Moolarben UG4 EP LWs 409-414

Re: IEAPM's Responses to DPHI Request for Supplementary Advice

On 25 October 2025, the NSW Department of Planning, Housing and Infrastructure (DPHI) requested the Independent Expert Advisory Panel for Mining (IEAPM, 'the Panel') to provide supplementary advice in relation to the Moolarben Coal Complex – Stage 1 (MP05_0117) Extraction Plan for Longwalls 409-414 (the 'EP').

FIGURE No:  
**5.16**

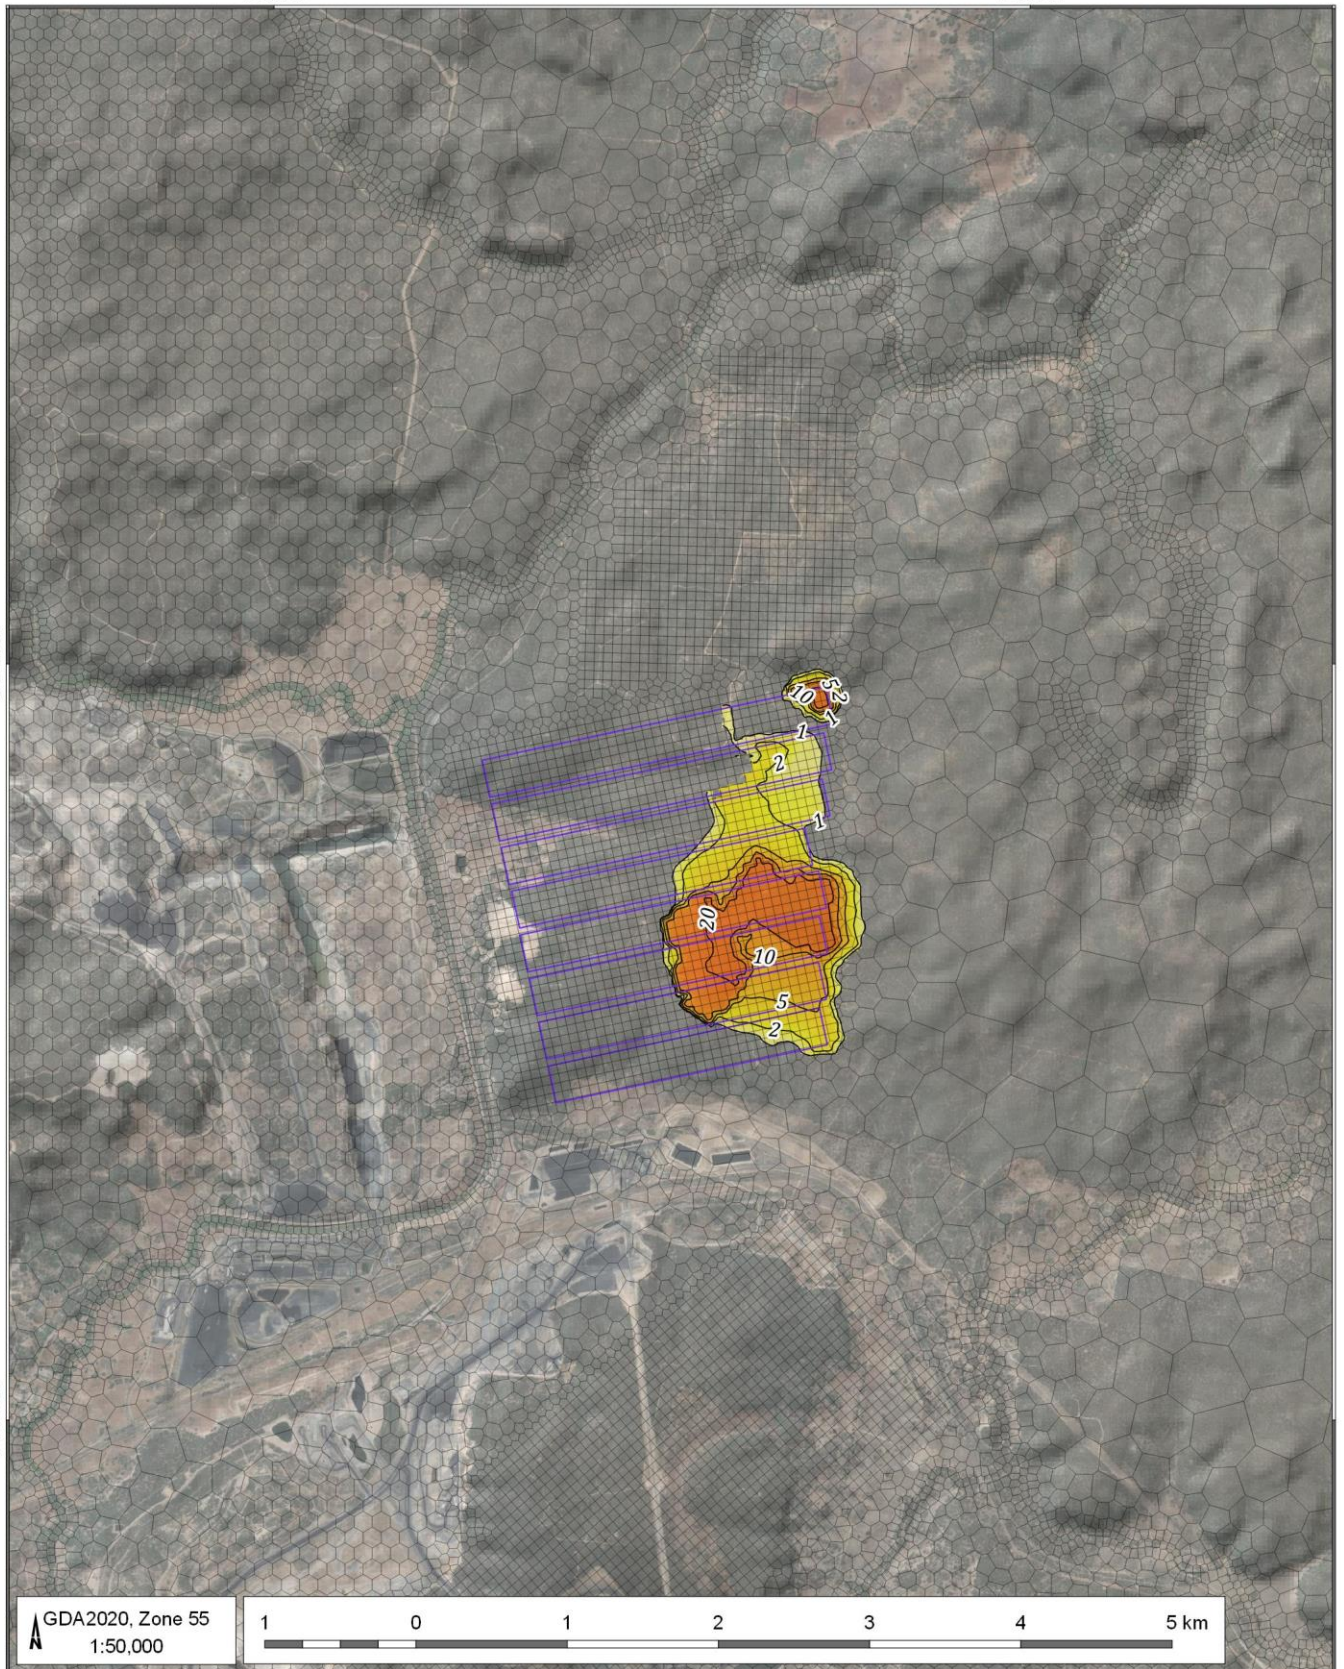
Two pieces of evidence for the Panel's concerns about the boundary conditions were the lack of drawdown around the perimeter of the model in the Ulan seam and Permian overburden at the end of mining (Figures 5.16 and 5.17, AGE, 2024) and the excessive contribution of the boundary conditions to the average water budget for the calibration period (Table 5.8, AGE, 2024).

The correction to the water budget table, although welcome, does not explicitly address the Panel's concerns about the lack of drawdown at the general head boundaries around the perimeter of the model domain and its impact on the calibration of the model and the model predictions. These are not discussed by AGE except to state, without clear justification, that "*...the water budget of the GHB applied to the outer edges of the model domain does not introduce bias in the model calibration and does not reduce the reliability of the model predictions.*"
